14 January 2021

EN010092 – Thurrock Flexible Generation Plant – Non-Material Change Request

Figure 1.1 Proposed causeway structure.

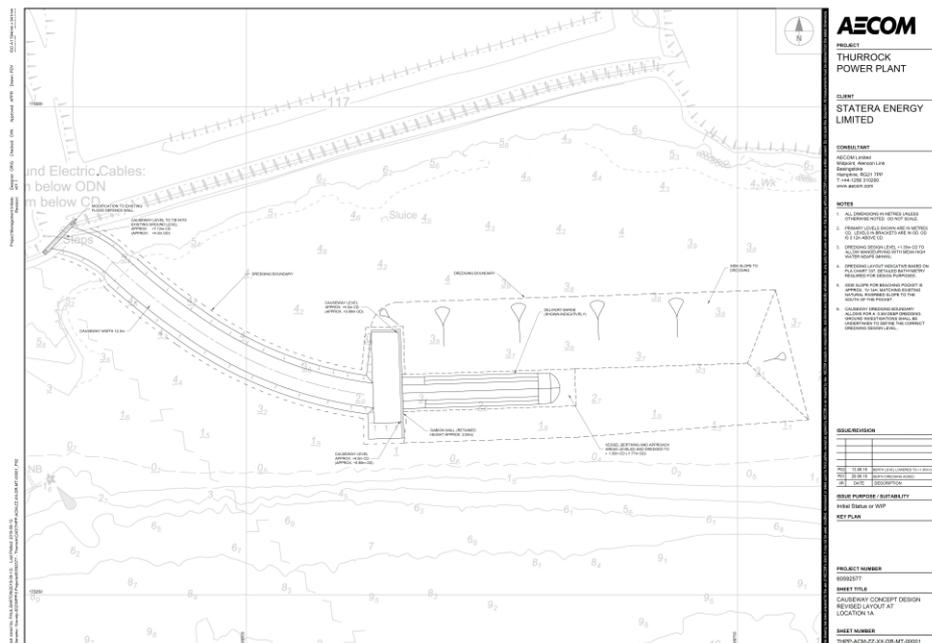
The Applicant has noted the comments made by the Environment Agency, Marine Management Organisation, Natural England and the Port of London Authority concerning saltmarsh creation in their relevant representations. Following a joint meeting with these parties (excepting the PLA, who were unable to attend) on 05 October 2020 the Applicant accepts that on balance it is now considered environmentally preferable not to use dredged material from the causeway construction to promote the establishment of saltmarsh on the mudflat in its lee.

APP-146 (A8.10 Outline Saltmarsh Enhancement and Maintenance Plan) will therefore be withdrawn and the draft DCO requirements and table of mitigation commitments in the Environmental Statement have been updated accordingly.

The dredged material will primarily be dispersed by water injection dredging (WID), as had already been described in the application for the balance of material that was not proposed for use in saltmarsh creation. WID of up to 13,000 m³ (of the total 16,100 m³ material) was assessed in APP-120 (ES Appendix 17.2). The 3,100 m³ balance of material to be excavated would be disposed of onshore. The Applicant considers it likely that some or all of this material could be used for the necessary raise of the main development site ground level, but as a worst case road transport of this material to a licensed disposal site has also been considered, and this could be accommodated within the construction HGV numbers that were set out in the application.

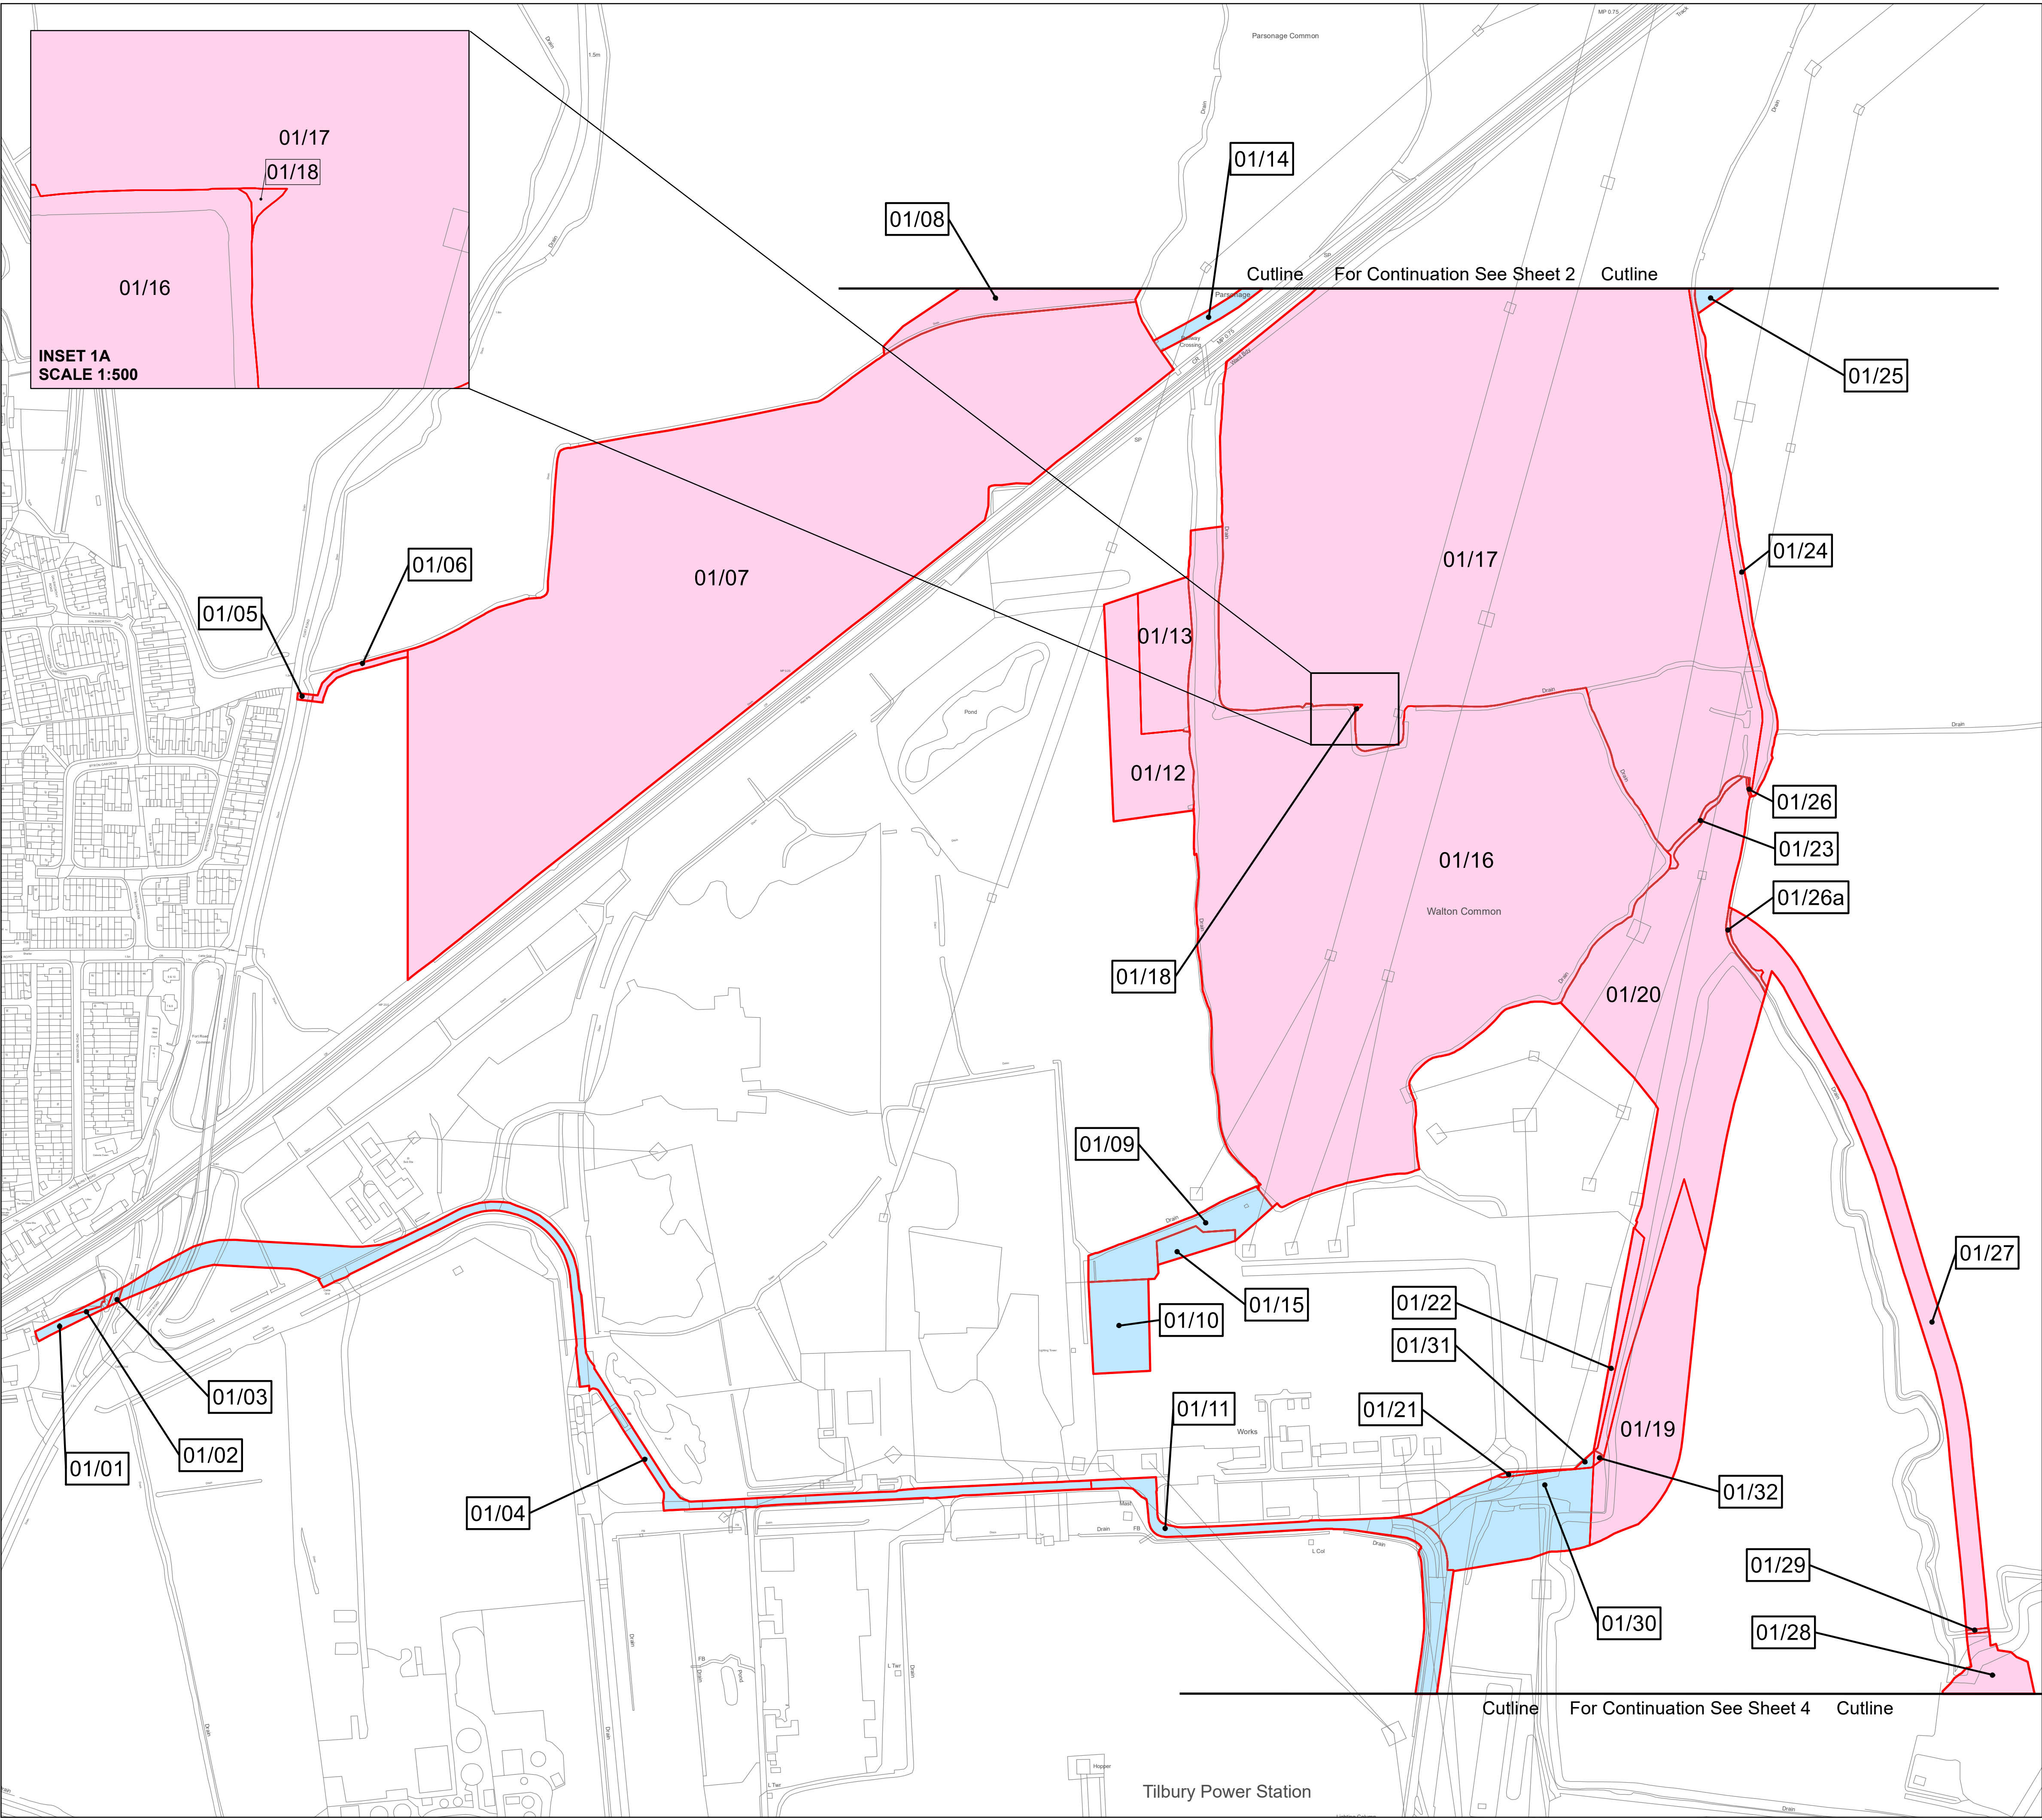
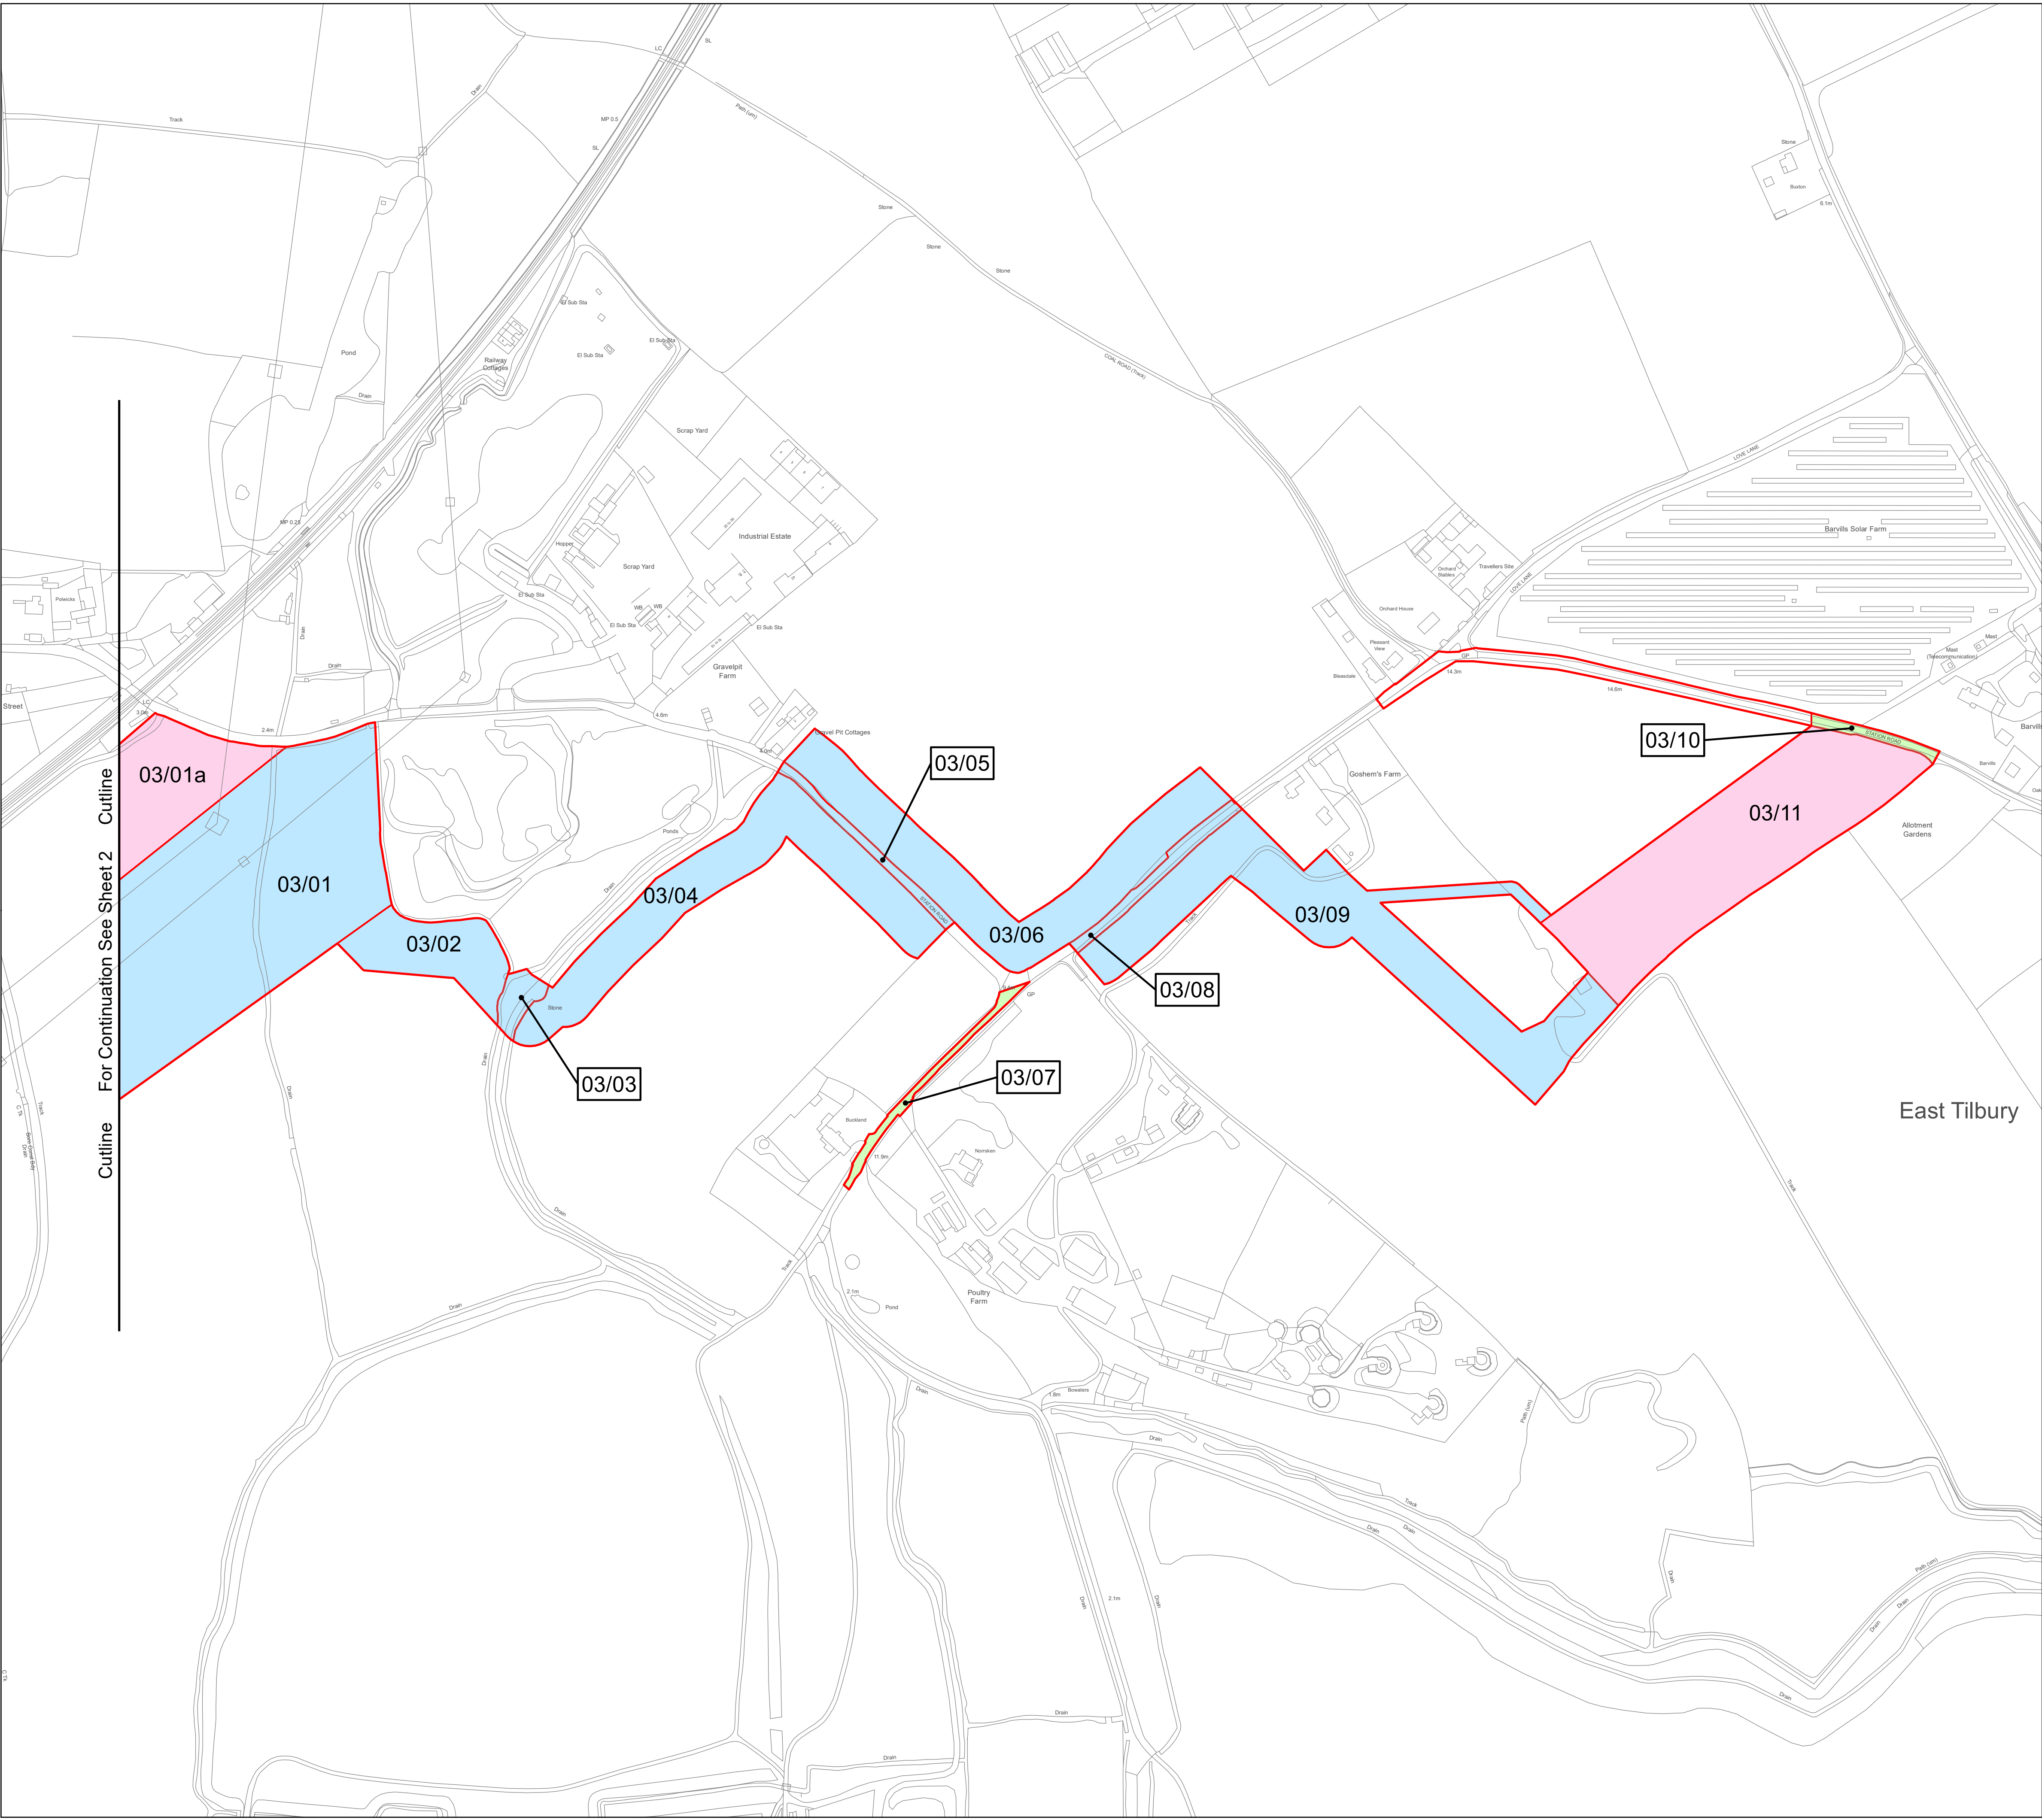
The Applicant has noted the objection made by RWE about the proposed acquisition and use of a plot of scrubland adjacent to the north-eastern corner of Tilbury Substation for habitat enhancement. This land forms part of Work 2 and was described as 'Zone F4' of the habitat creation and enhancement proposals in the Environmental Statement (ES). It comprises around half of plot 01/20 in the Land Plans.

Following further discussion with RWE and a review of other available land within the Order Limits, the Applicant has decided to remove the Zone F4 land from the Order Limits. Habitat creation is instead now proposed in the area of agricultural land between the main development site and the railway line (part of what is described as 'Zone C' in the ES), within plots 01/17 and 02/06.

The change does not add any new land to the Order Limits and reduces the land affected by the powers sought. The removal of 2.2 ha from Plot 1/20 has been proposed in direct response to a request from the affected landowner. The amendments made to the Book of Reference in relation to this change do not add any new interests.

This does not affect land acquisition as the entirety of plots 01/17 and 02/06 were already proposed for permanent freehold acquisition. The remainder of plot 01/20 remains in the Order Limits as it is required for the construction of an access route to the main development site.

The replacement habitat creation within Zone C provides an equivalent quantum of habitat and an increase in biodiversity net gain value compared to the previous proposals for Zone F4. The label 'Zone F4' is retained and applied to the new location of replacement habitat creation in updated ES documents, as discussed below.
